Town & Country Planning Act 1990 (as amended)
Town and Country Planning (Development Management Procedure) (England) Order 2015
Approval of matters reserved by condition imposed under BE/18/17/PL relating to conditions 4-archaeological works, 5-surface water drainage, 9-landscape scheme, 10-protection of existing trees/bushes/shrubs, 14-foul drainage, 15-ecological enhancement scheme, 17-landscape management plan, 18-details of laying out timetable for provisions & future maintenance of Public Open spaces, 20-10% decentralised & renewable or low carbon energy sources, 21-street lighting scheme, 23-vehicle access, 25-car parking spaces, 27-construction of road(s), footways & casual parking areas & 28-Travel Plan statement.
Land West of New Barn Lane Bersted,,

Arun District Council have decided to **REFUSE details reserved by condition for the following reasons:**

The application to discharge Condition 5 imposed under reference BE/18/17/PL is refused by virtue of insufficient detail. The following detail is absent from the submission and should be incorporated as part of any future application to discharge this condition:

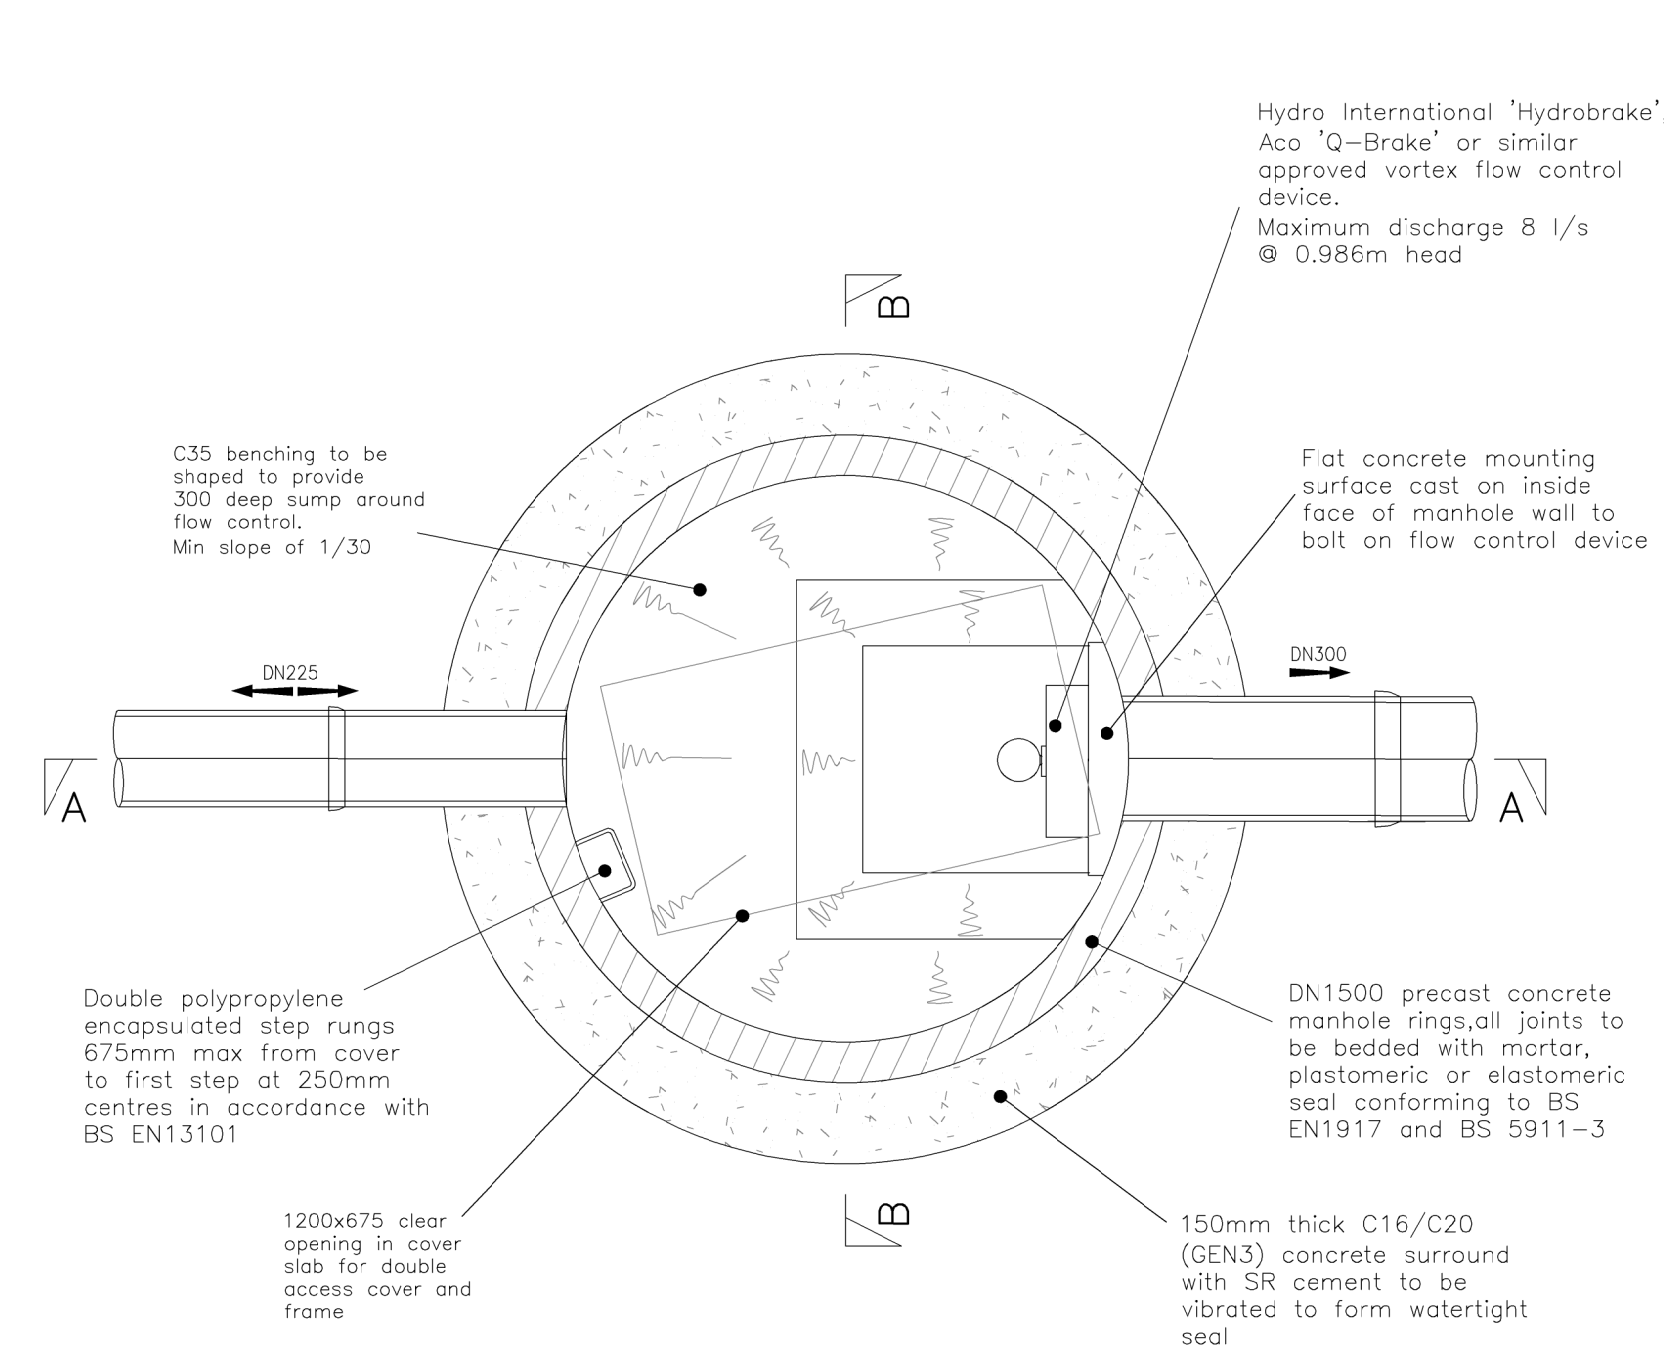
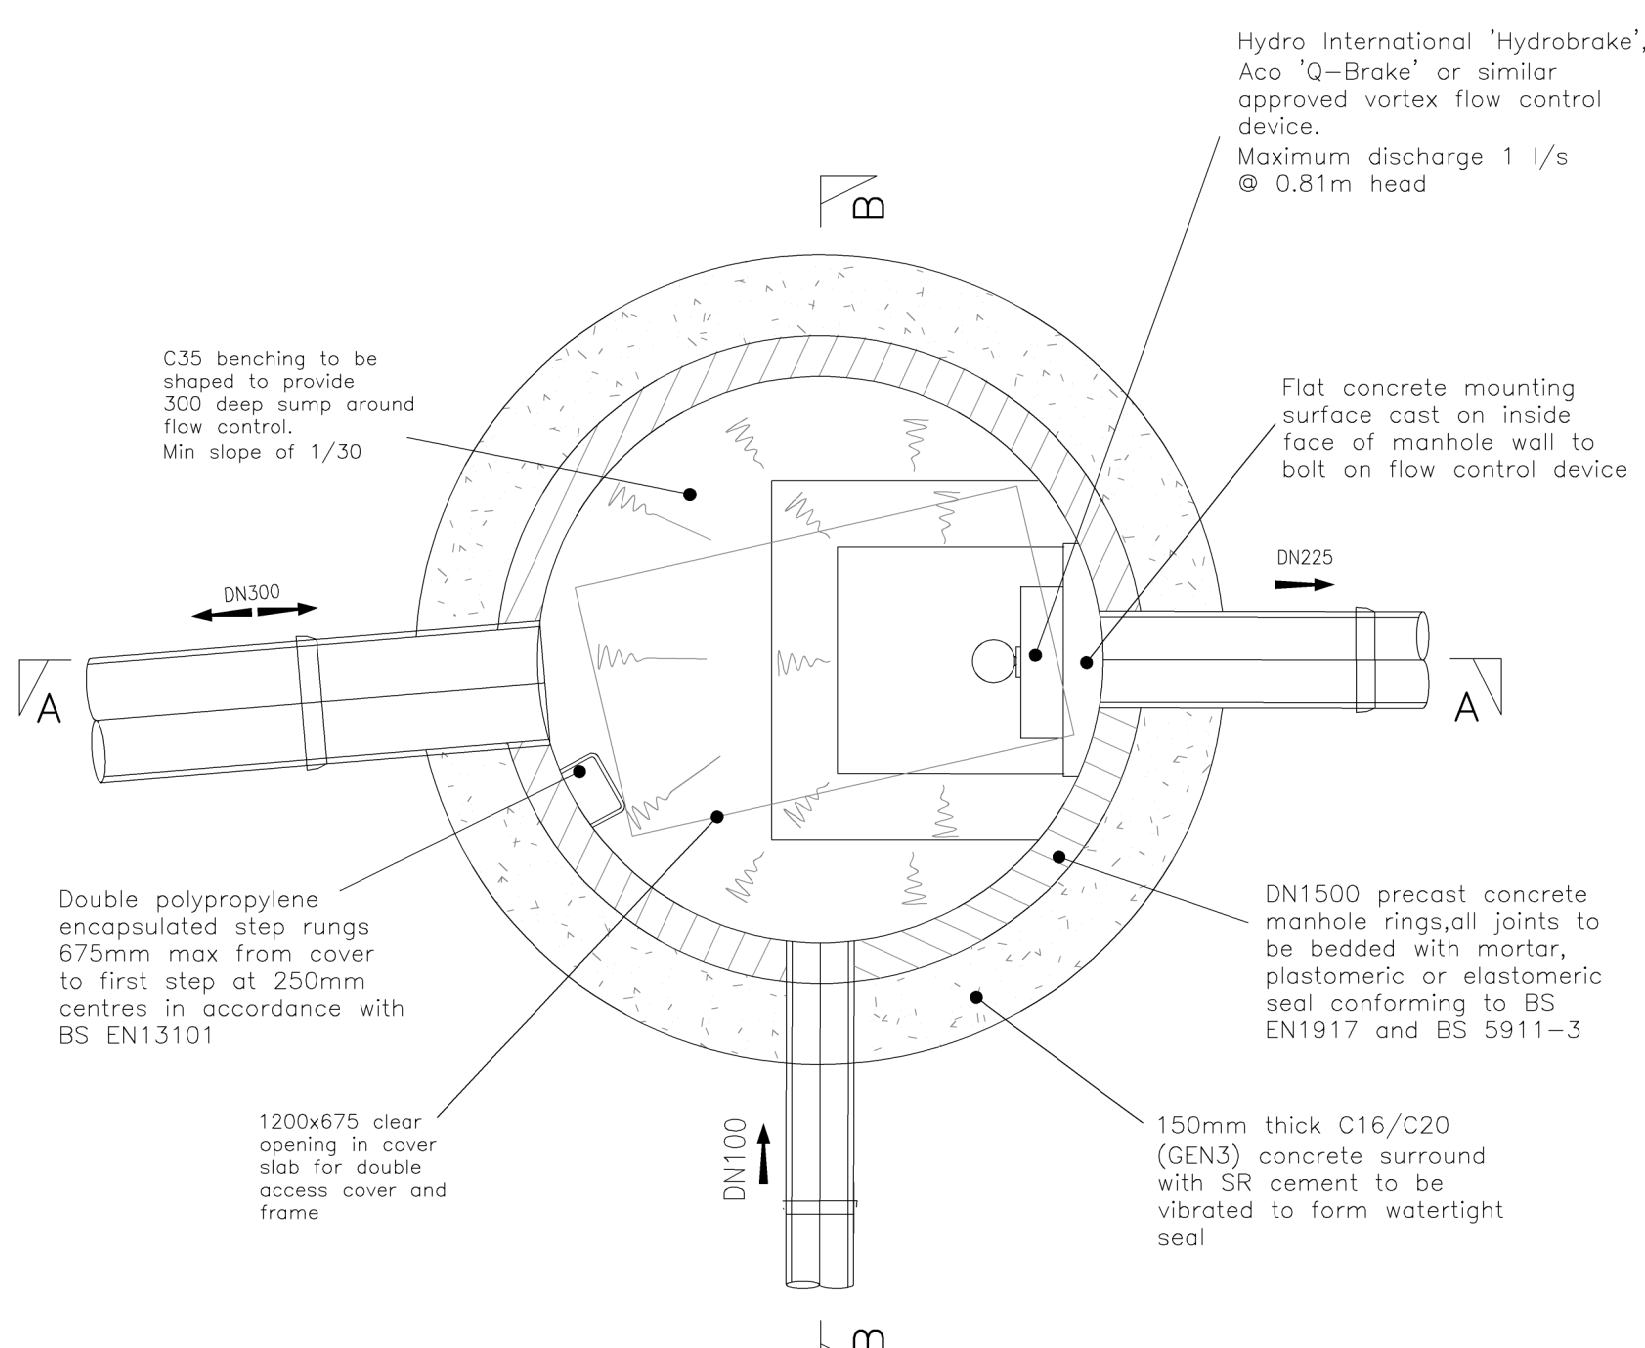
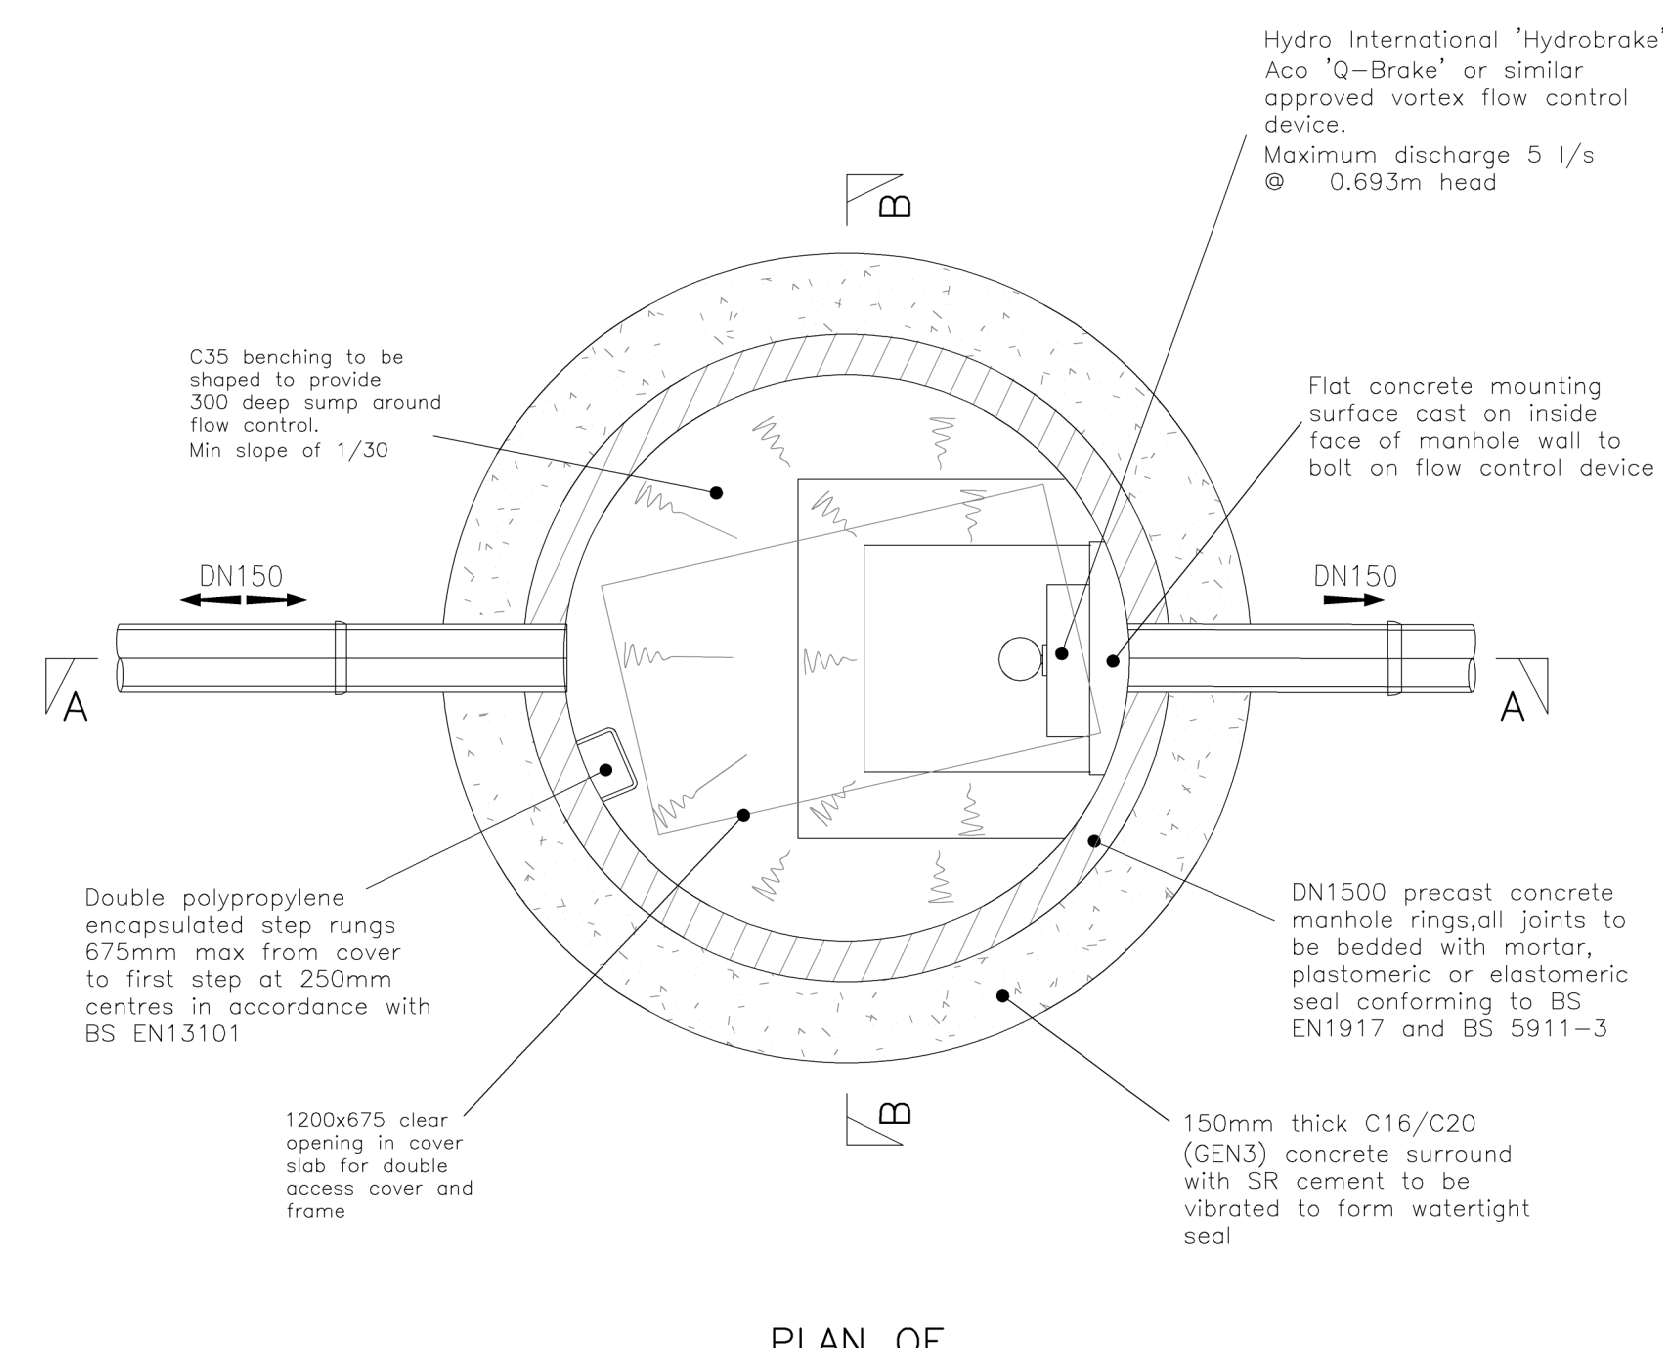
- Hydrobrake flow rates have been specified on the layout plans. However, confirmation is required that 1l/s flow restriction rate at CPM2 is achievable without risk of blockage?

- Pipe diameter downstream of SW1 has not been provided on the layout plan.
- Overflows have been included in the control chambers. Please provide for these in the microdrainage results, and show that they are not active during the 100 year plus climate change event.
